From: [REDACTED]
To: [Hinckley SRFI](#)
Subject: Hinckley RNFI - Objection
Date: 03 February 2025 10:35:54

Following on from the latest amendment to the proposal please see below as to why I strongly object and feel that critical details have been overlooked.

Appendix A Part 2 - Vehicle Tracking Sheet 1

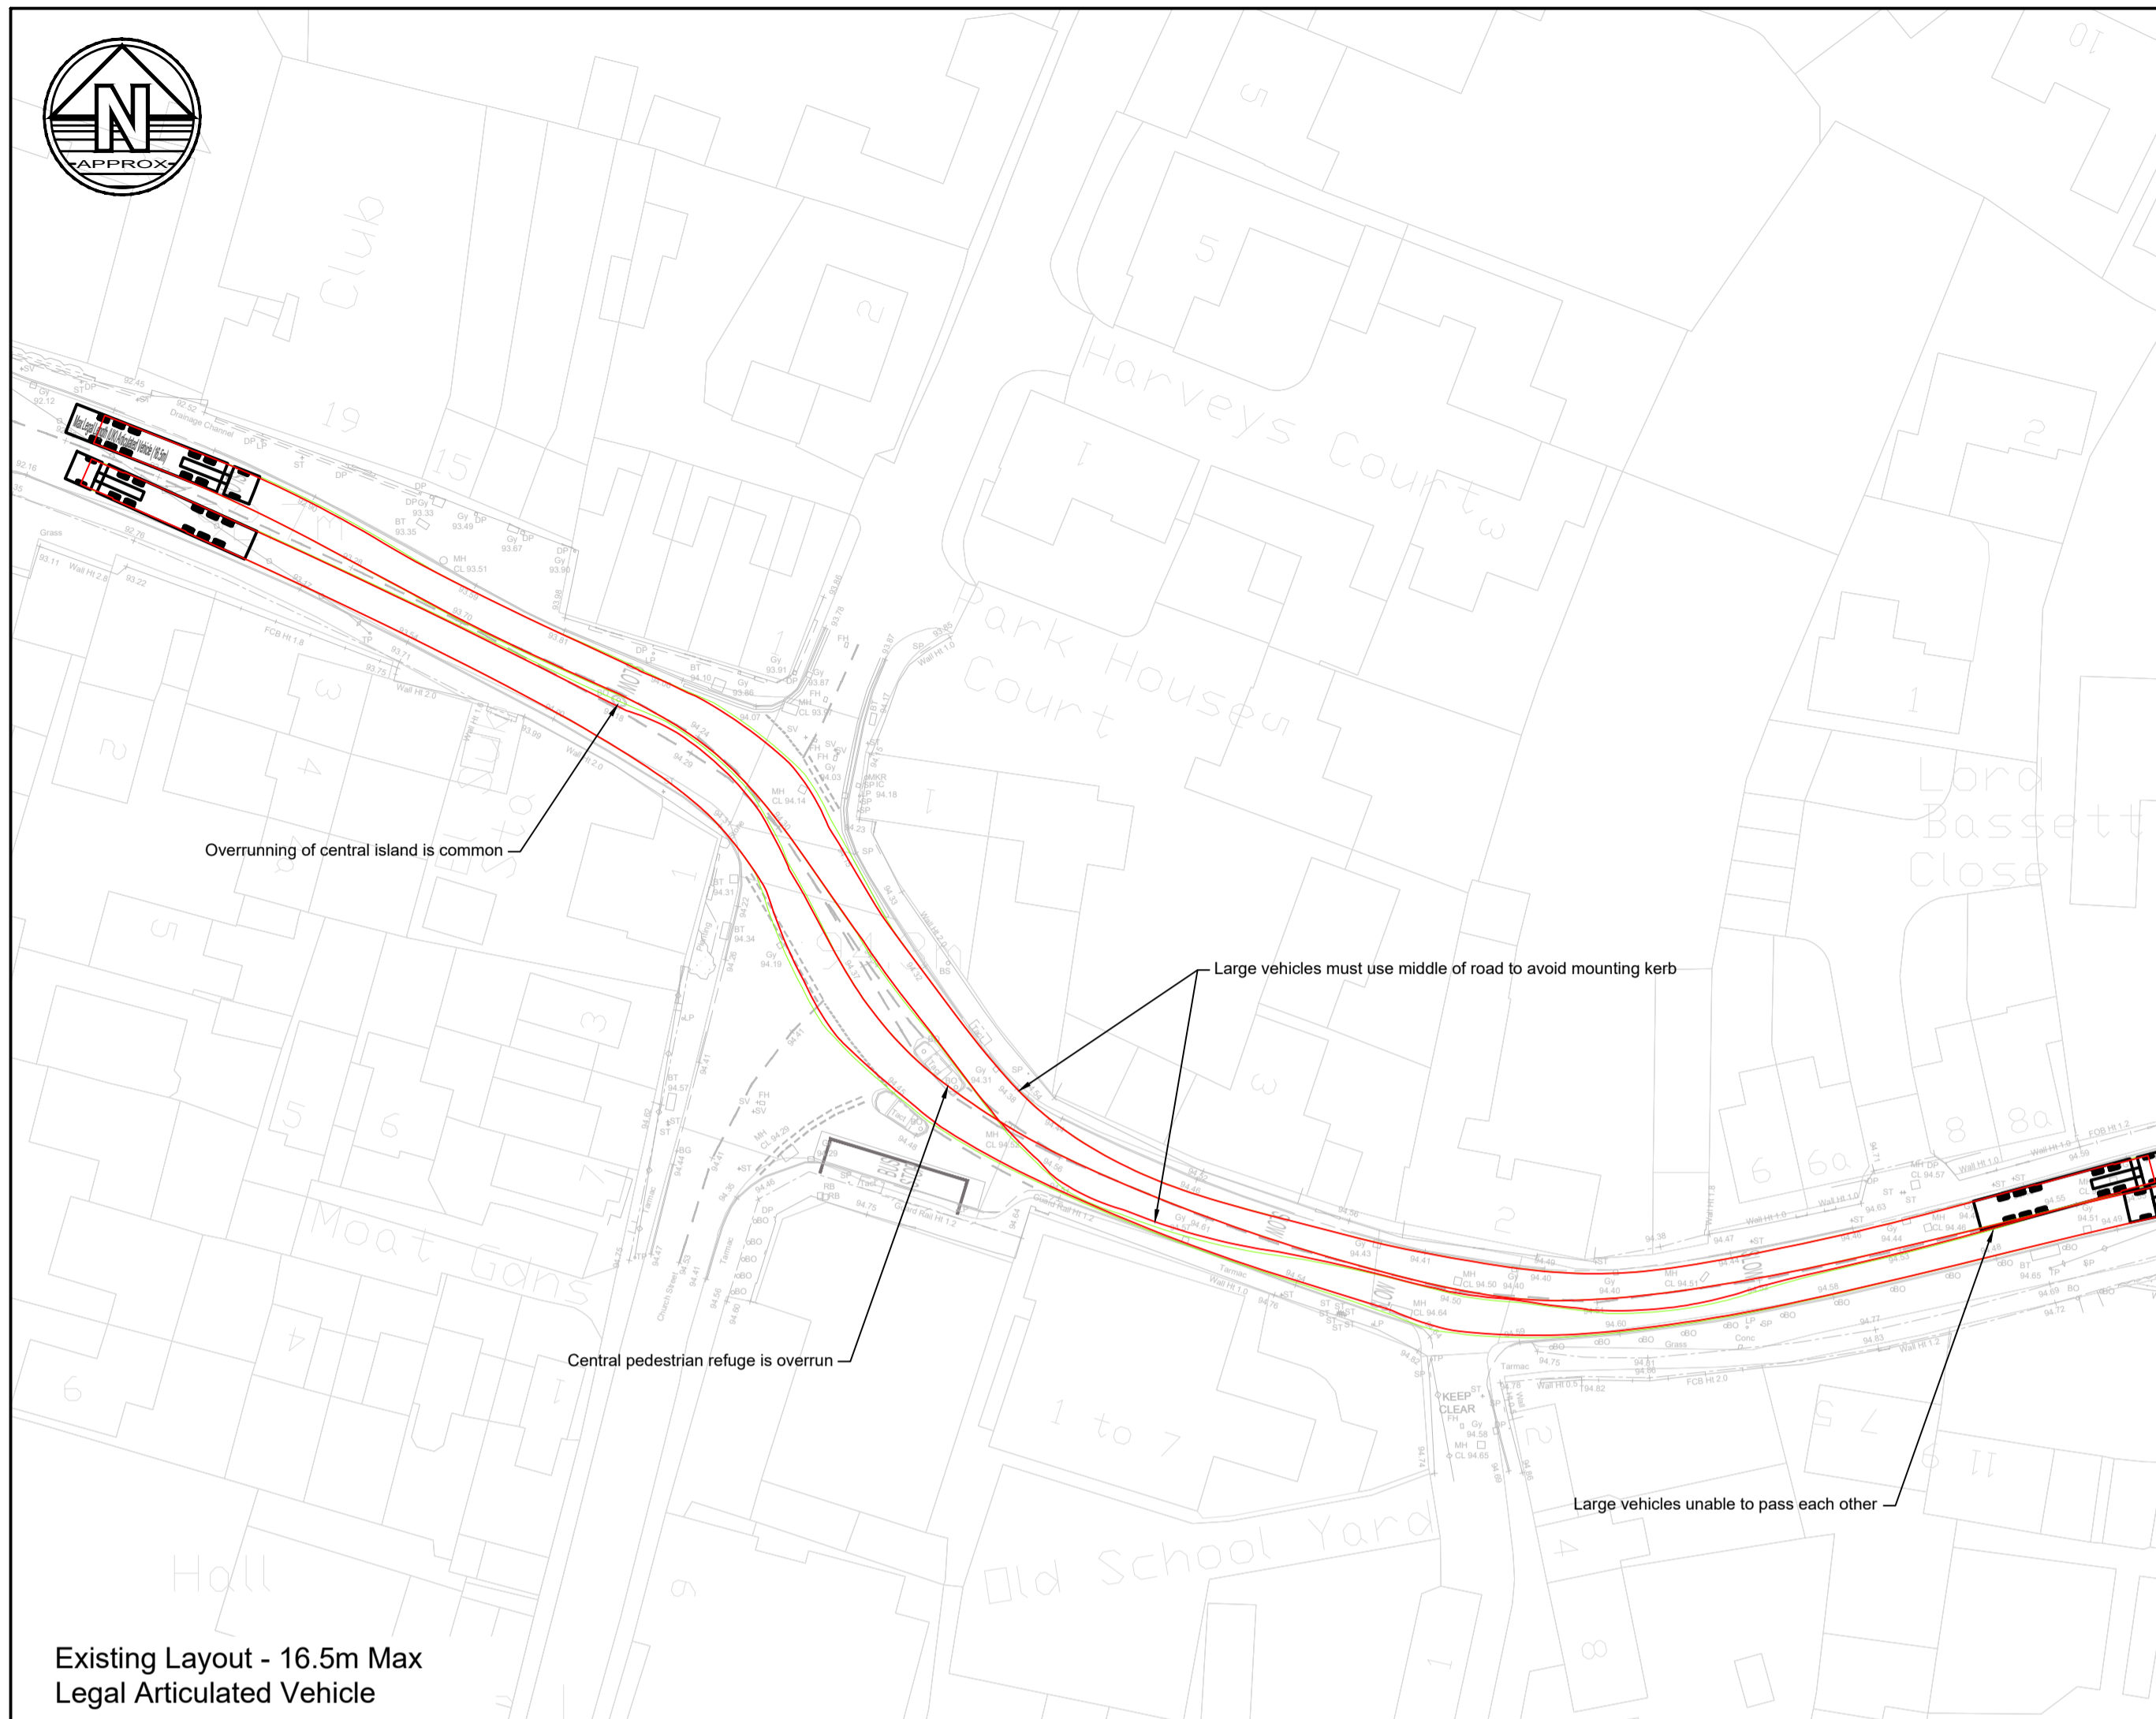
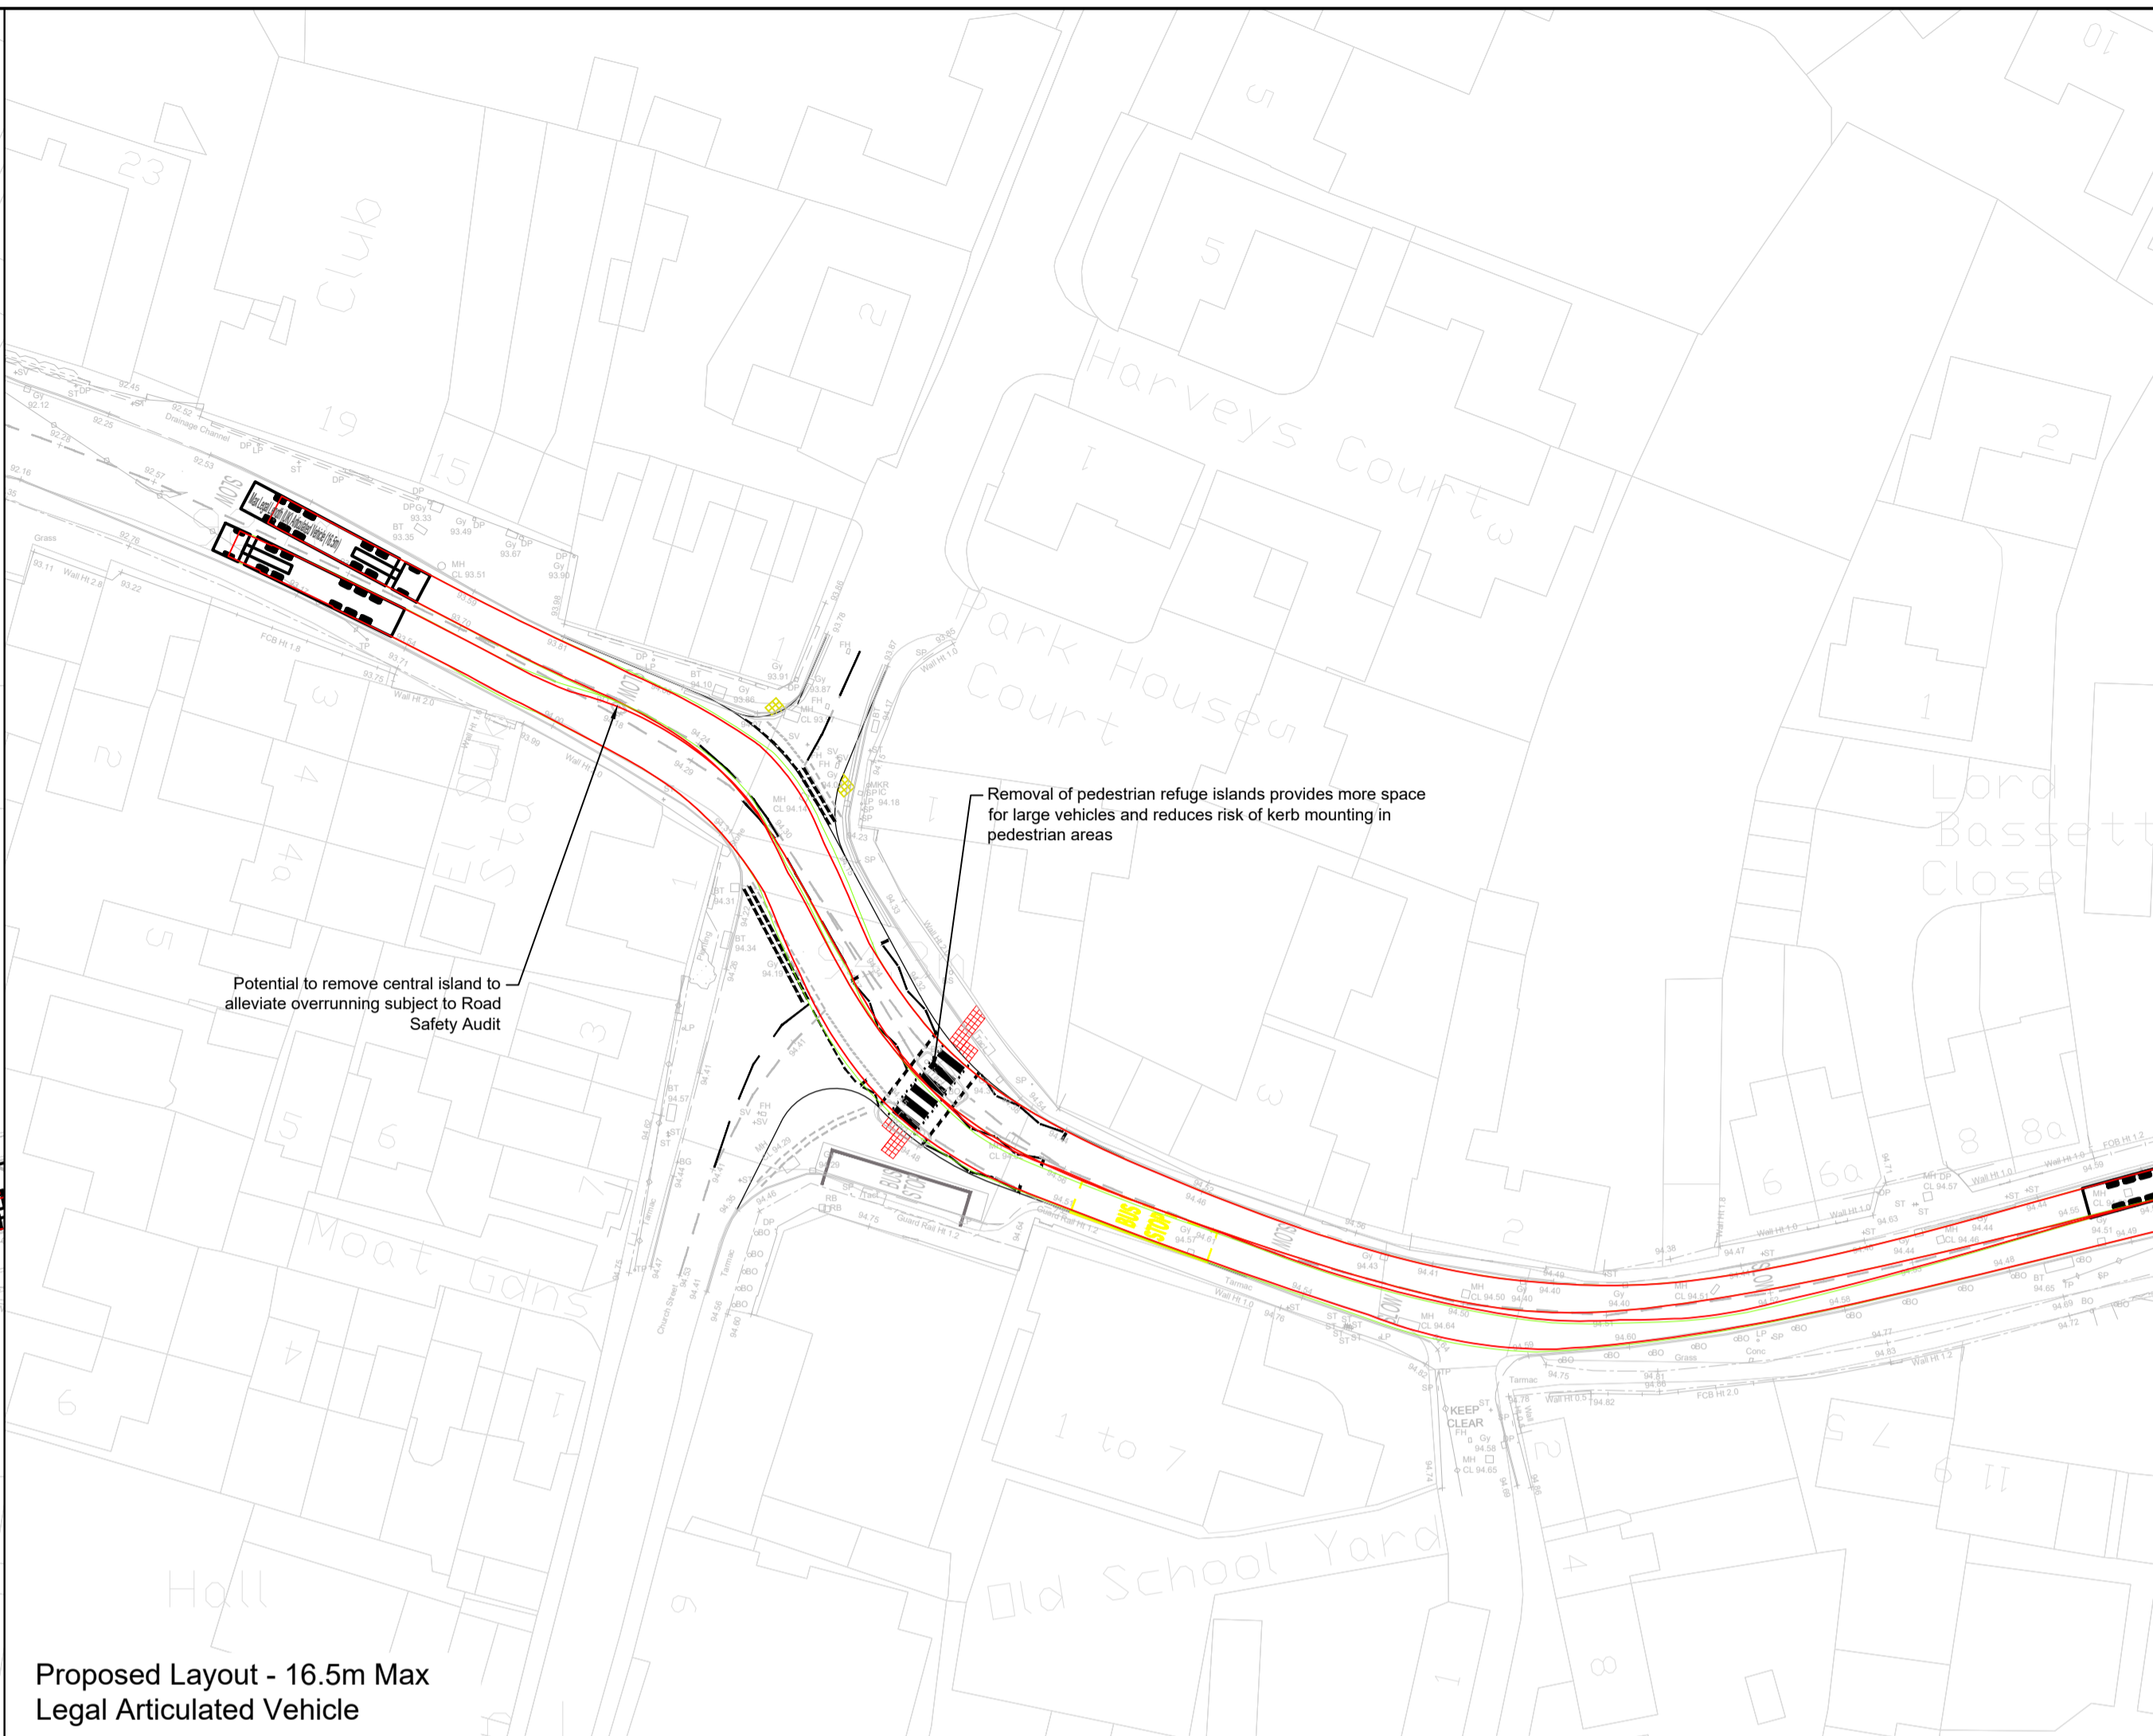
The suggestion of a narrow road to reduce the amount of HGVs passing through the village is bizarre. What stops either vehicle? There is no provision for this? What if there is already a school bus making it's way through? What if there is village traffic already making it's way through? What if a farm tractor is already making it's way through? No consideration has been given to delivery vehicles, removal vehicles, refuse lorries, school buses which may already be using any of the other roads in the village and need to make use of the suggested narrow road.

There is no provision made for vehicles parked on the side of the road (entirely legally) outside of the nursery, or the properties on Leicester Road?
